Application by Anglian Water Limited for an Order Granting Development Consent for the Cambridge Waste Water Treatment Plant Relocation project

The Examining Authority's written questions and requests for information (ExQ1)

Issued on 24 October 2023

MAIN CONSTRUCTION (FIRST PHASE)

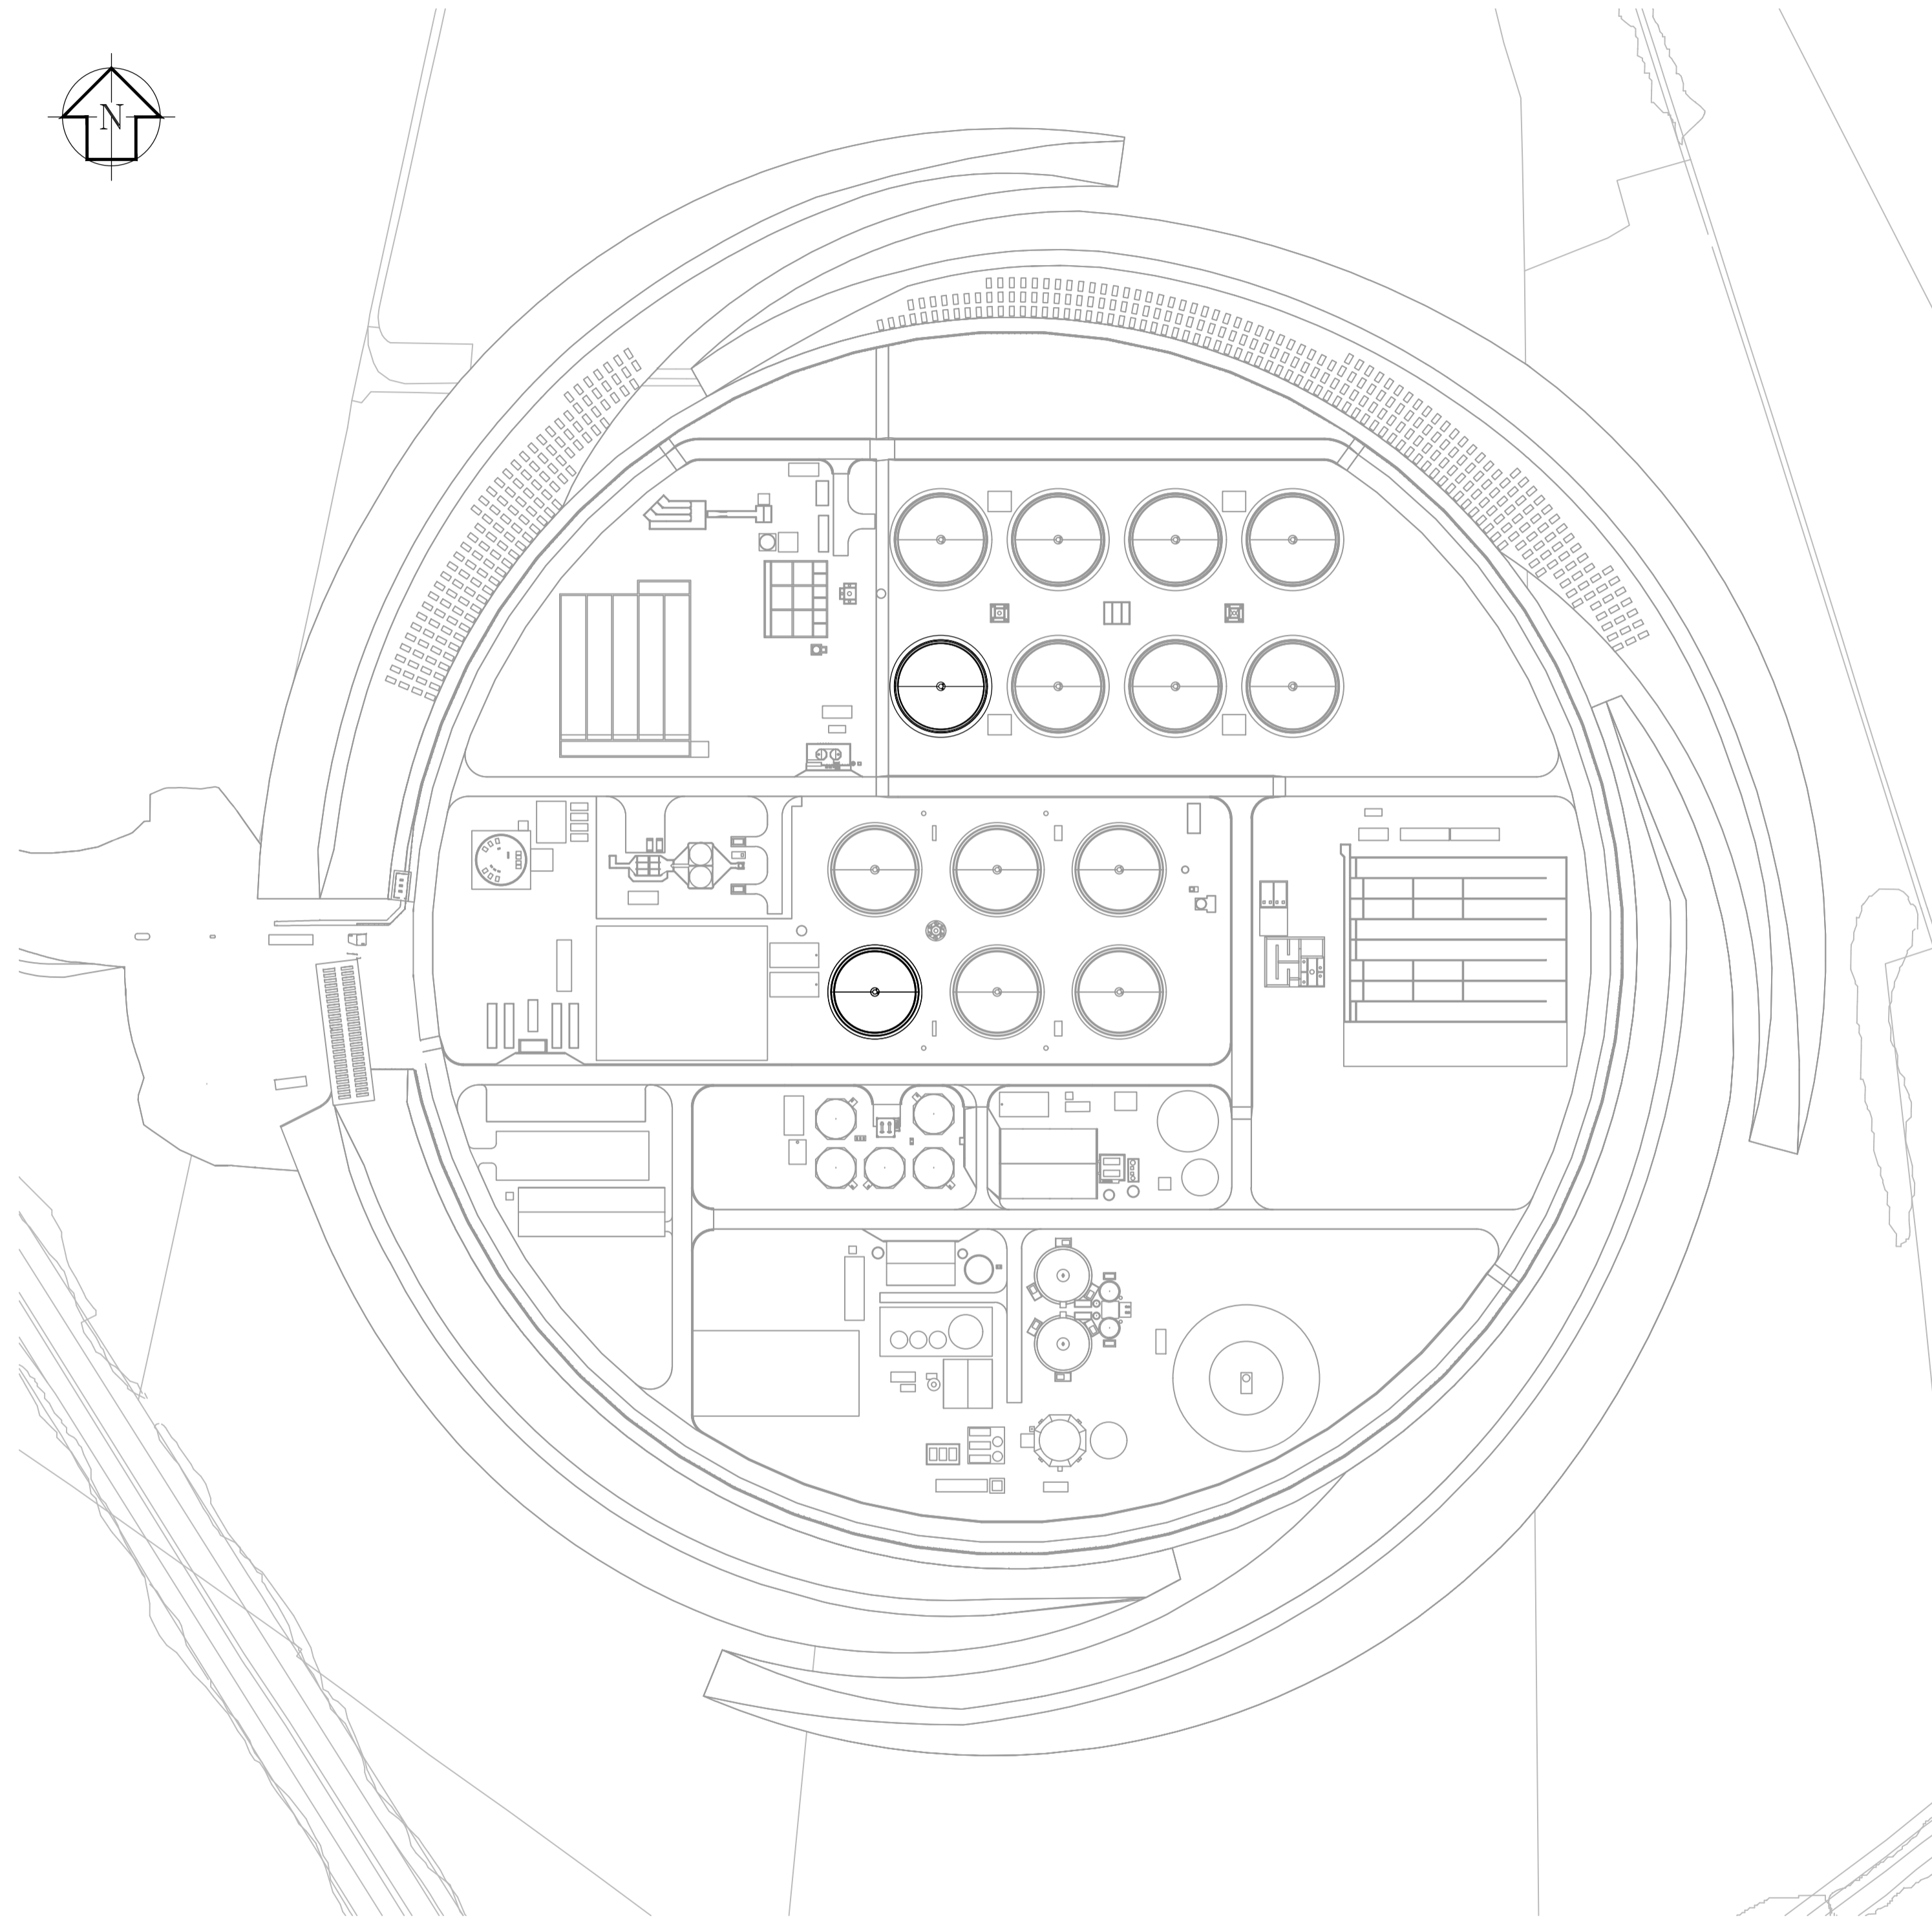
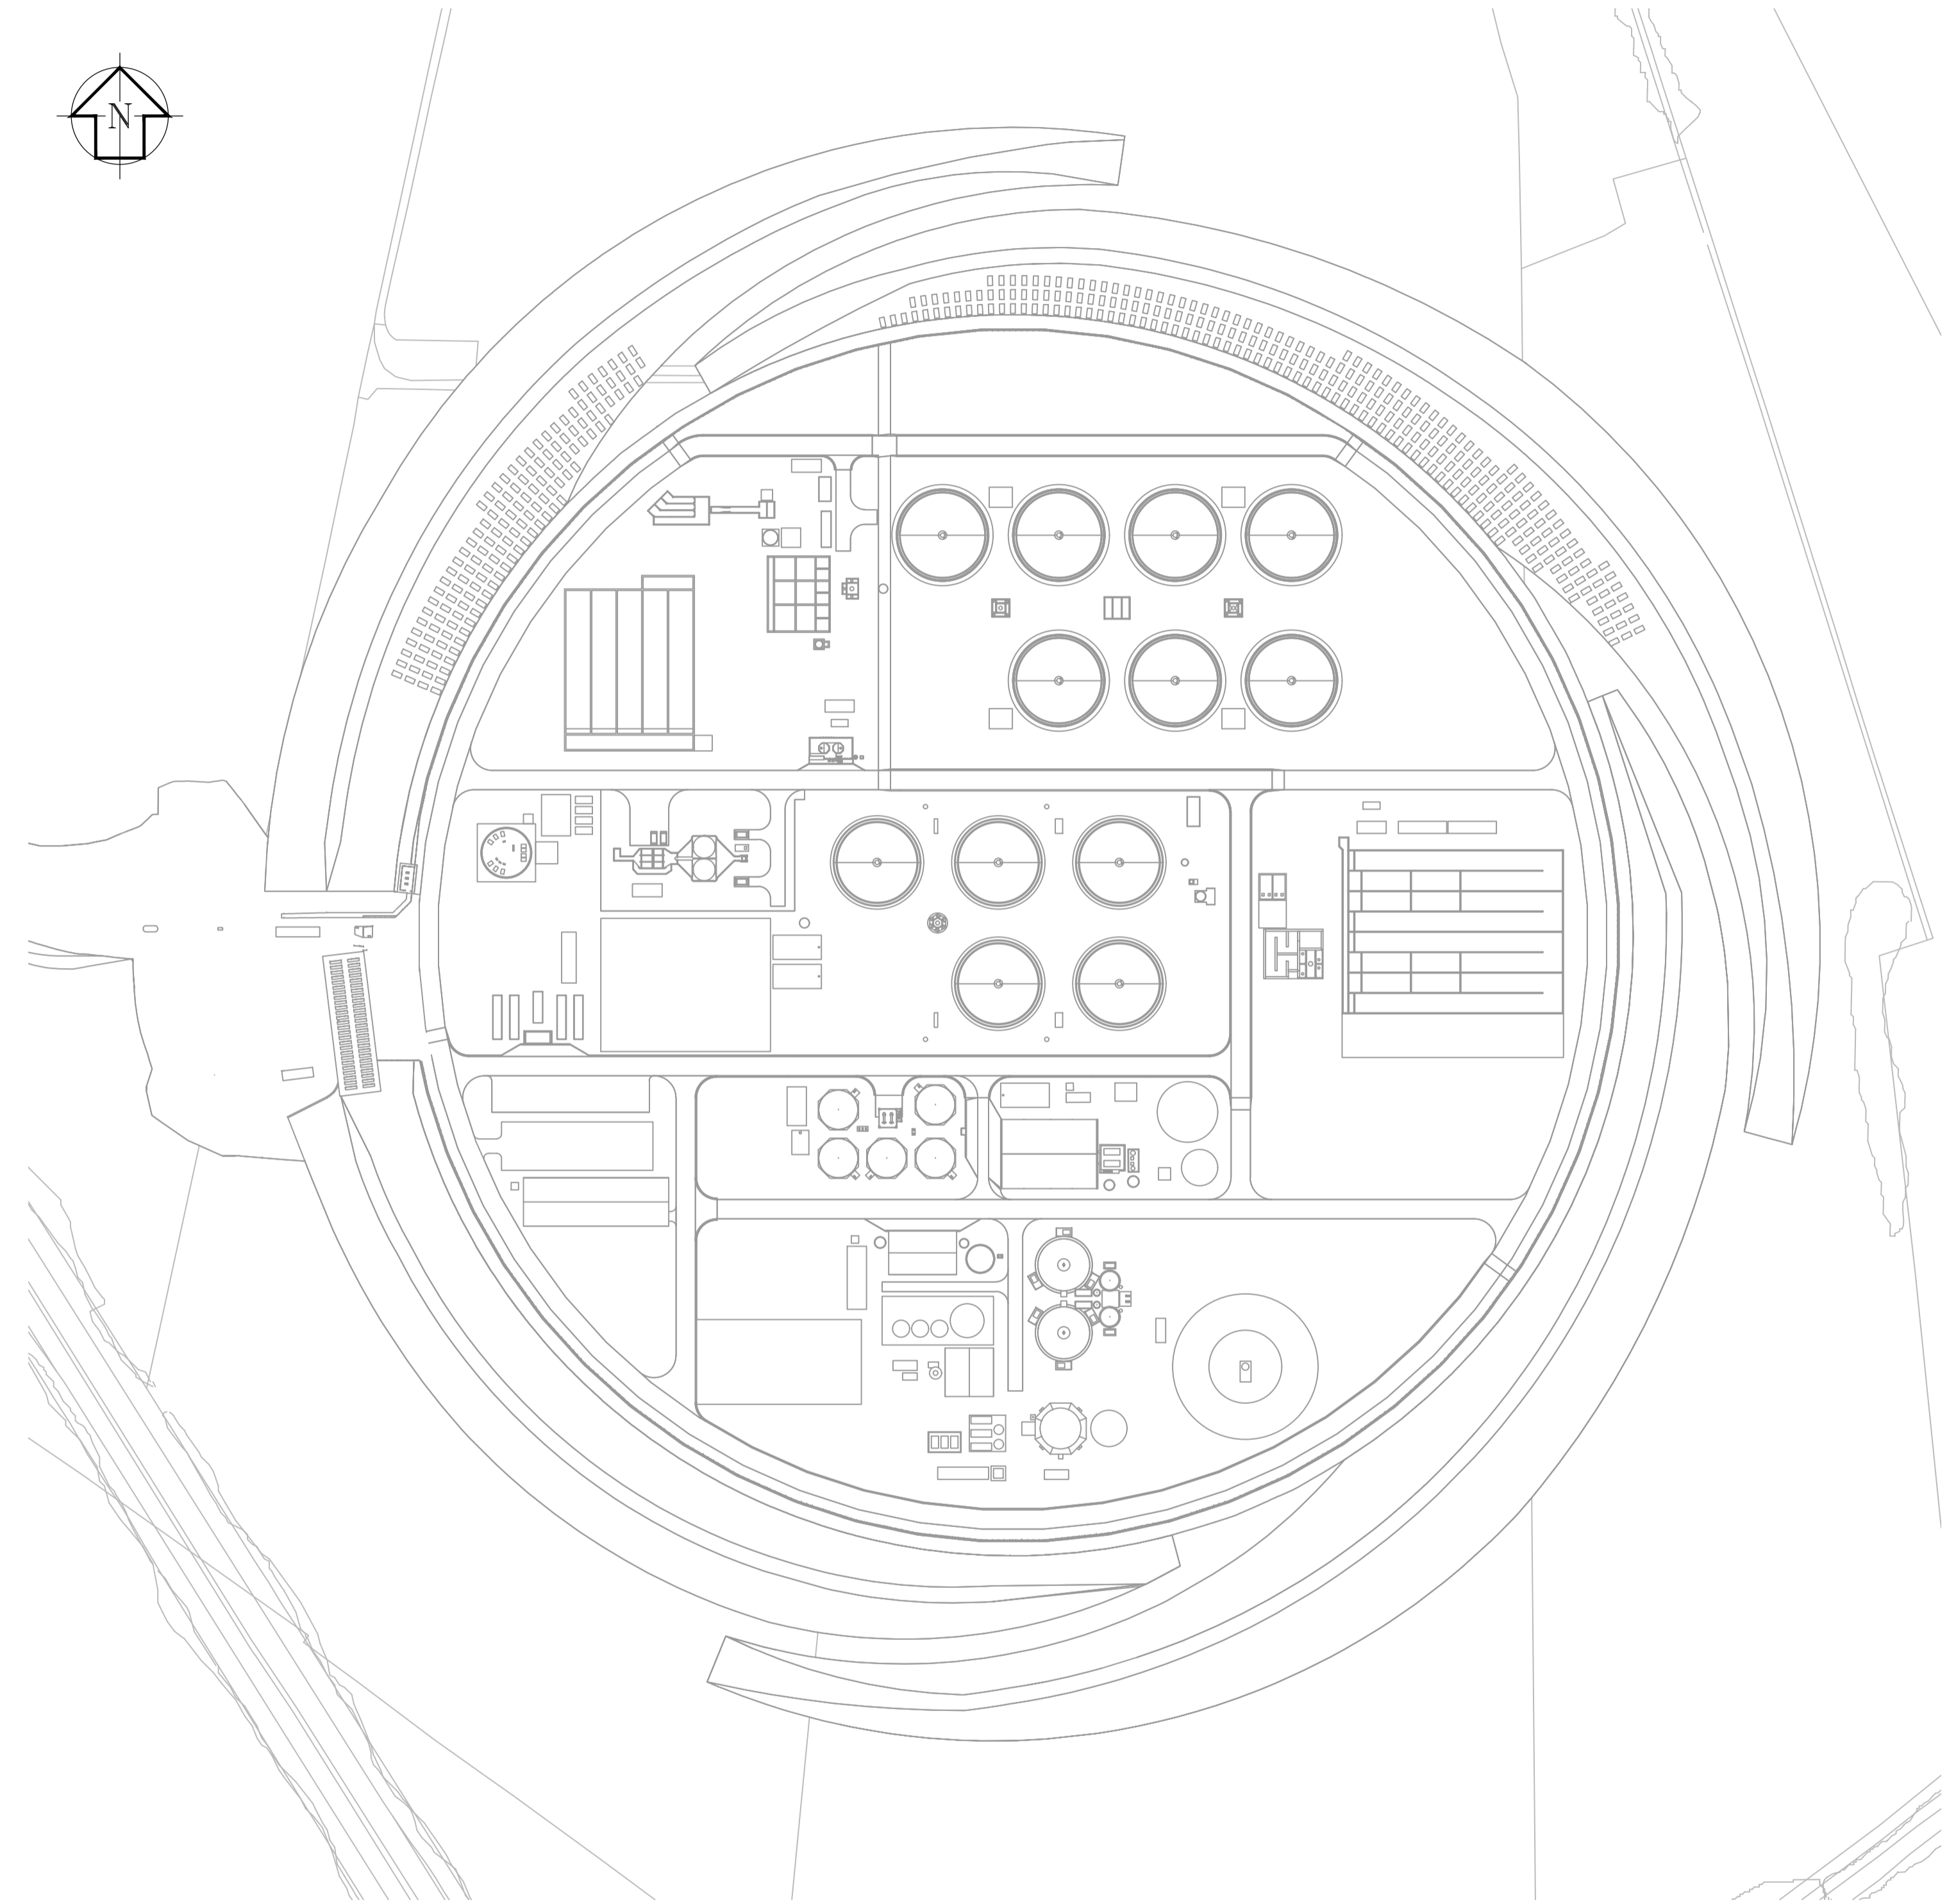
1.2	Applicant	<p>Plans and Documents</p> <p>Figure 1.1 of Guide to the Application [AS-138] refers to “Main construction (first phase)” and to “Extension – 2nd phase (from 2036)”. Please provide a drawing indicating the extent of each phase.</p>
